28th April 2021

Application No: EP/22/21/HH
Site Address: 15 The Plantation East Preston BN16 1LD
Description of works: Erection of rear extension and loft conversion with rear dormers and side gables

Thank you for your internet representation made on 27th April 2021 which has been recorded as an objection with the comments as follows:

10 West Facing rear Elevation

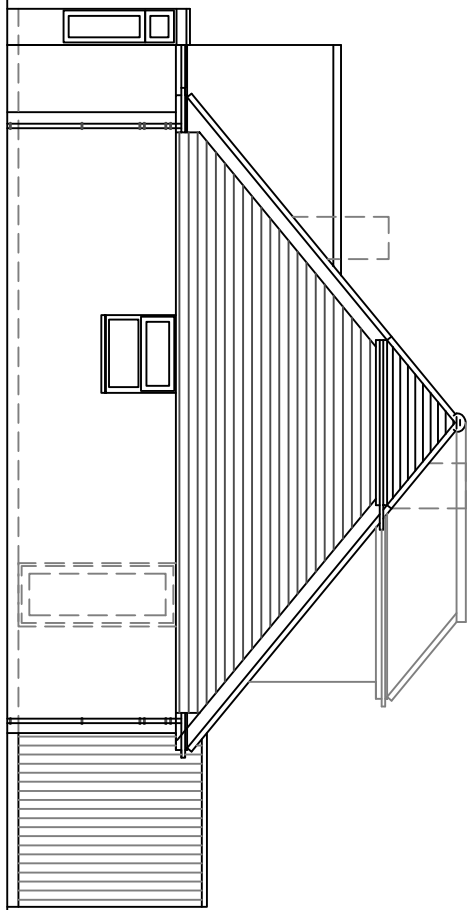
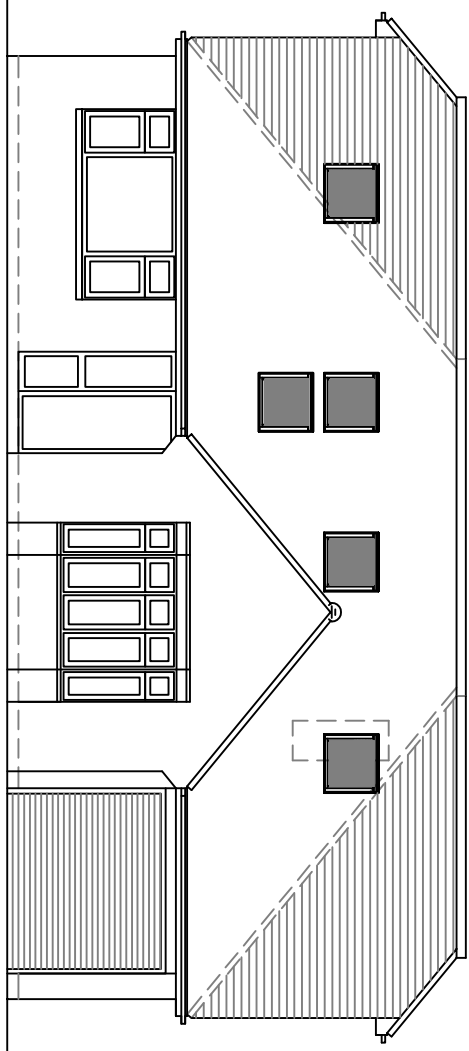
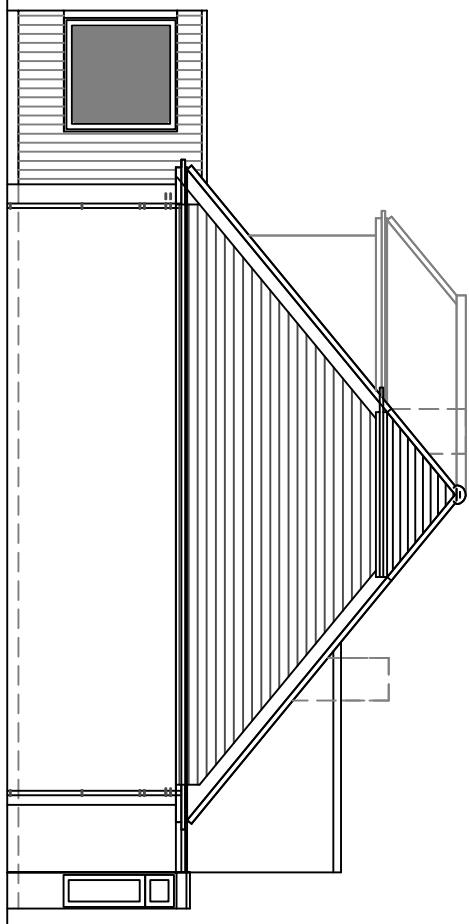
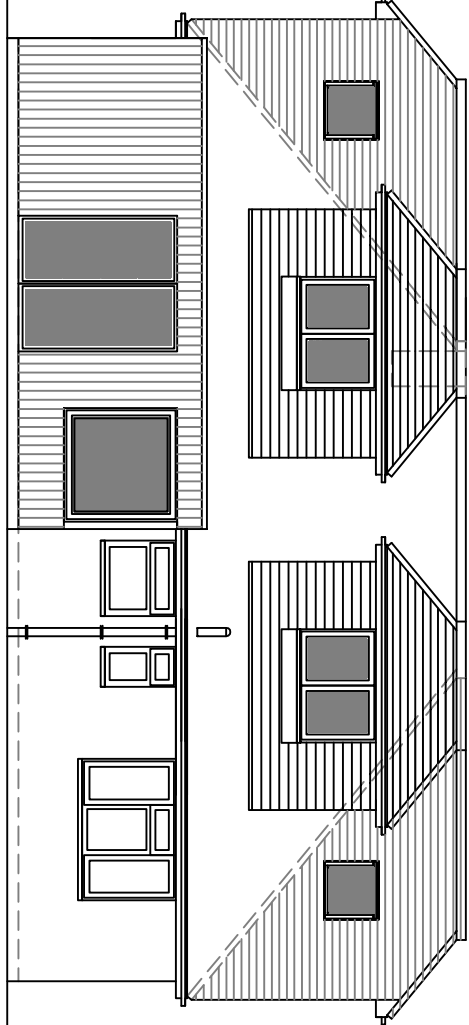
Having studied the redevelopment plans for the above property, we believe that they are totally out of character with other homes in The Planation. Neighbours on three sides will be overlooked by the proposed dormer windows , reducing privacy and restricting natural light to neighbours on either side.

6 Ground Floor Plan

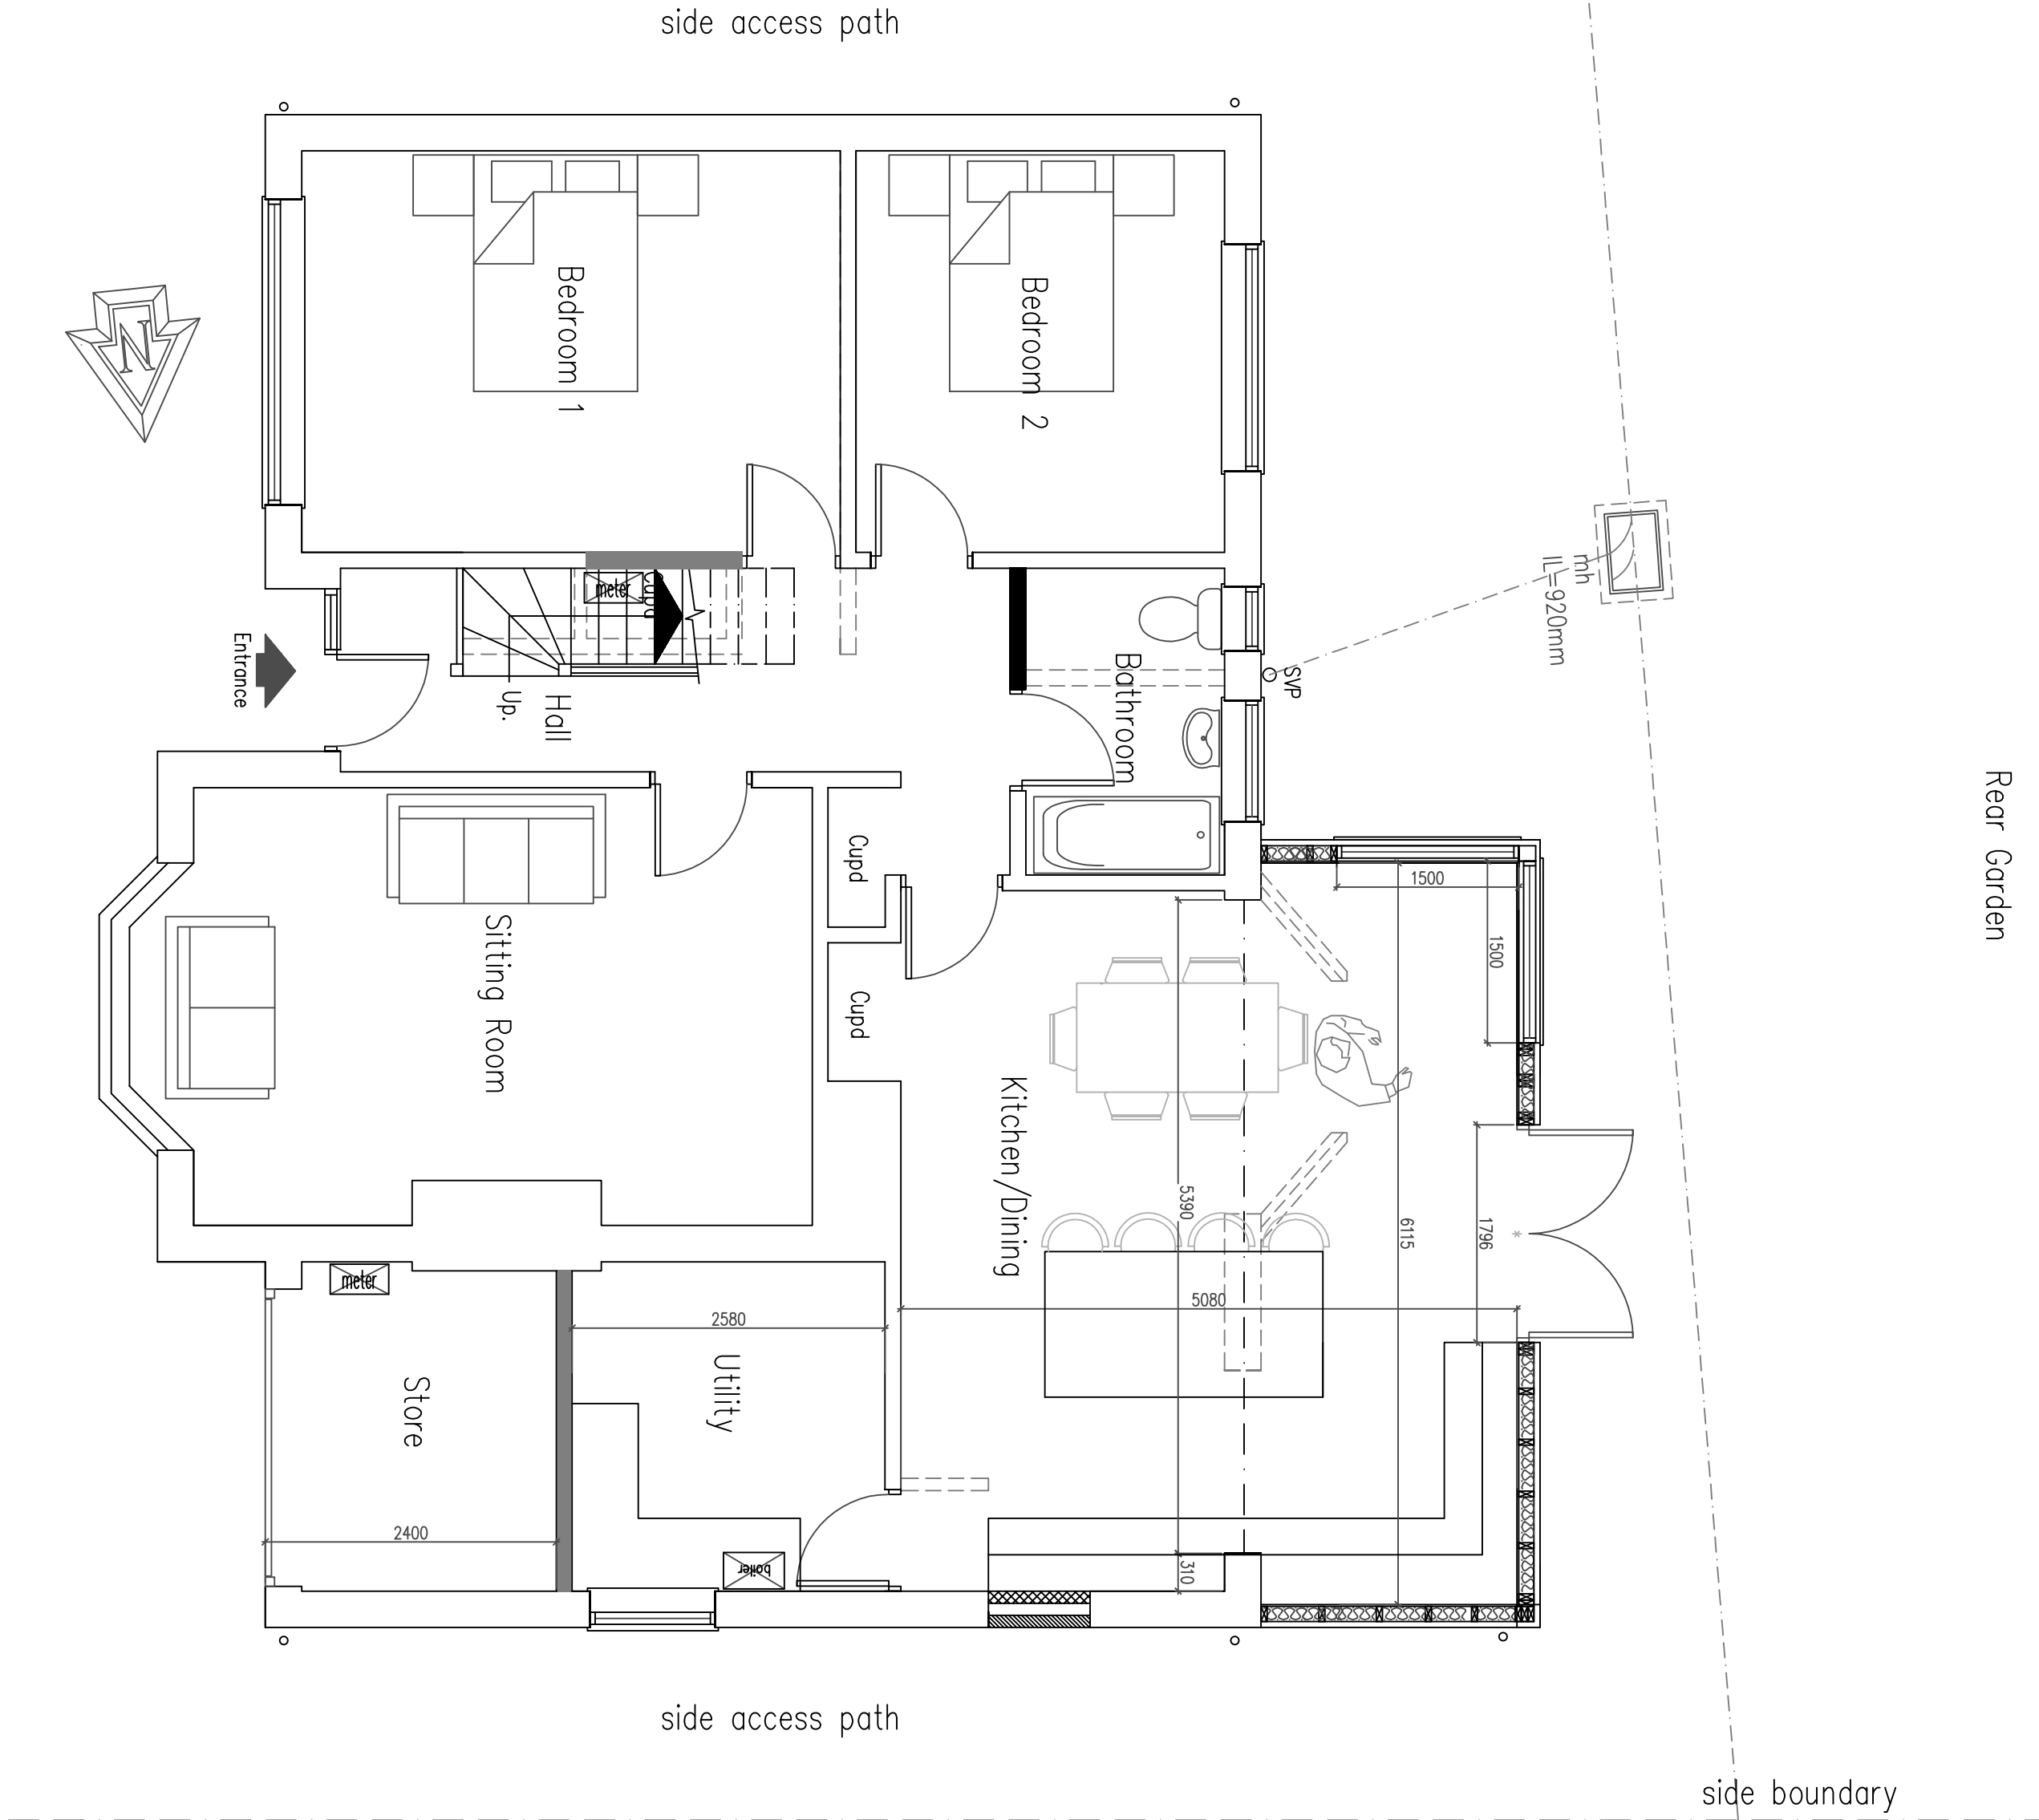
The application wishes to convert a two bedroom bungalow into a five bedroom house, bringing with it the obvious change in habitation and traffic. Having converted the integral garage into a store and utility room, there will be a lack of parking facilities (the present driveway only allows for two vehicles) thus forcing the occupants to use the road - with no street lighting in The Plantation, this is likely to cause difficulties for the rest of the neighbours.
